RFI

RFI #: 85
 Date: 3/23/2012
 Job: EB-02 Keller Springs Lofts
 Phone: 877-777-5115

Subject: Water heater types

8 UNIT B1 - ALT G
SCALE: 1/4" = 1'-0" OCCURS AT: (2) TOTAL UNITS ON SITE

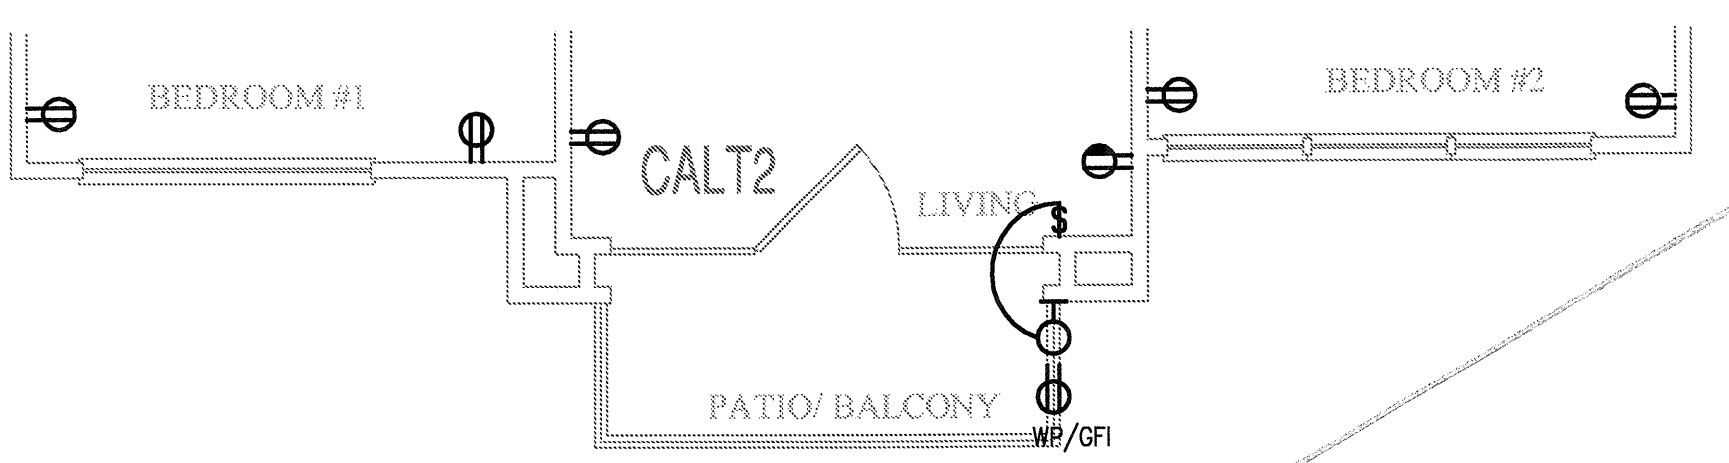
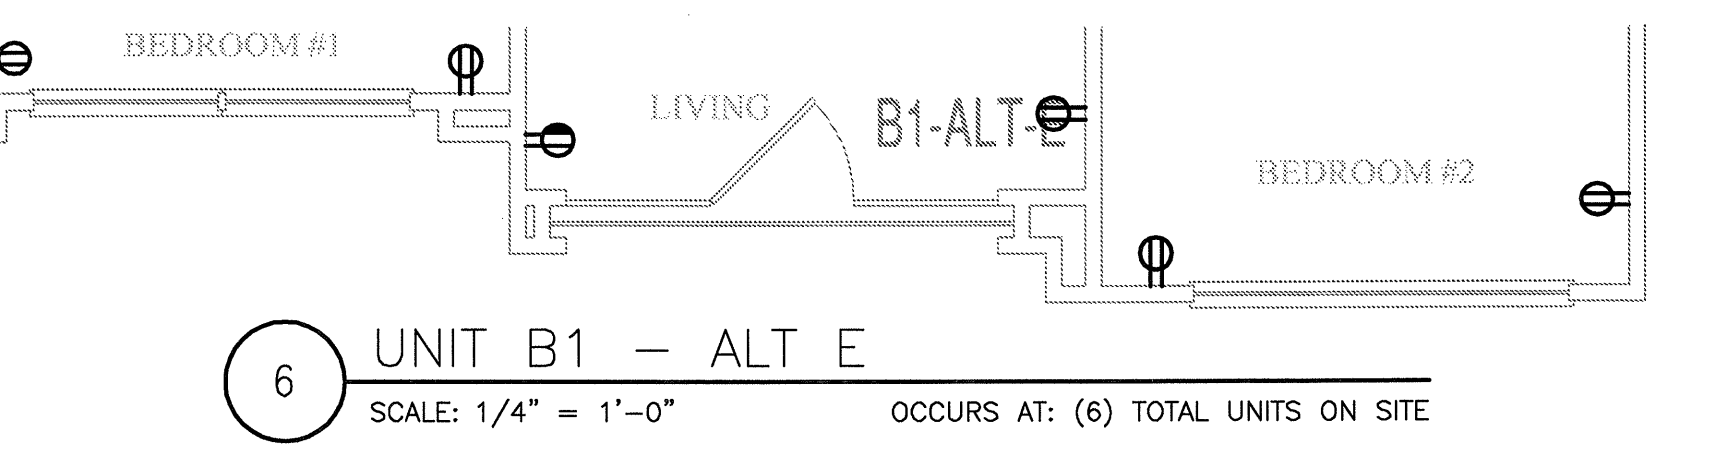
Request: On sheet 2.5 detail 12 showing the Alt G unit, it does not have a total unit count at the bottom like the rest of the Alt units show on the page. Please revise sheet 2.5 to show total unit count of the Alt G units.
Date Required: 6/22/2012

Response: Sheet 2.5 has been updated - see next page.
